Response to the Examining Authority's 2nd written questions

Interested Parties Ref: **NWWFC-AFP012 and NWWFC-AFP011**

Mr Dewi Parry and Mrs Helen M Parry

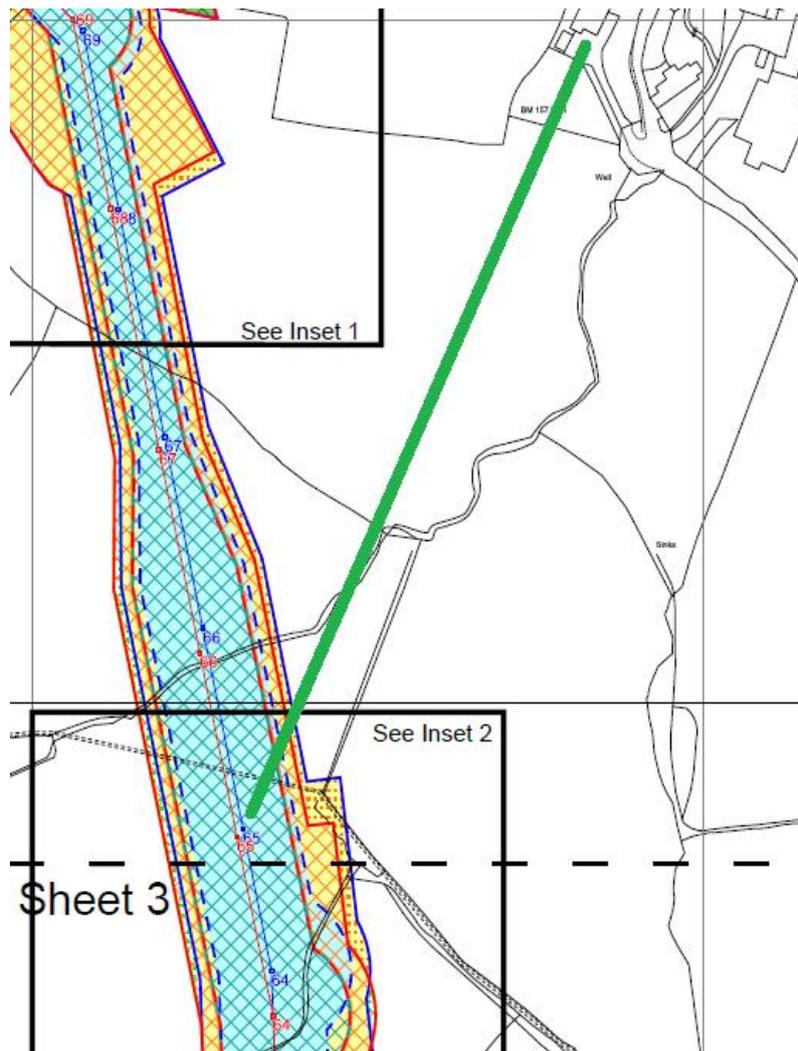
Pole 65 position has changed and is at risk of coming into view of College Farm residential receptors because it may be shifted away from intervening trees that may offer screening. This would be a wholly unacceptable outcome as pole 65 is one of the most directly prominent poles in southerly views. We require assurances from the Applicant that this is not the case and that Option A scenario will also make full use of the trees for screening.
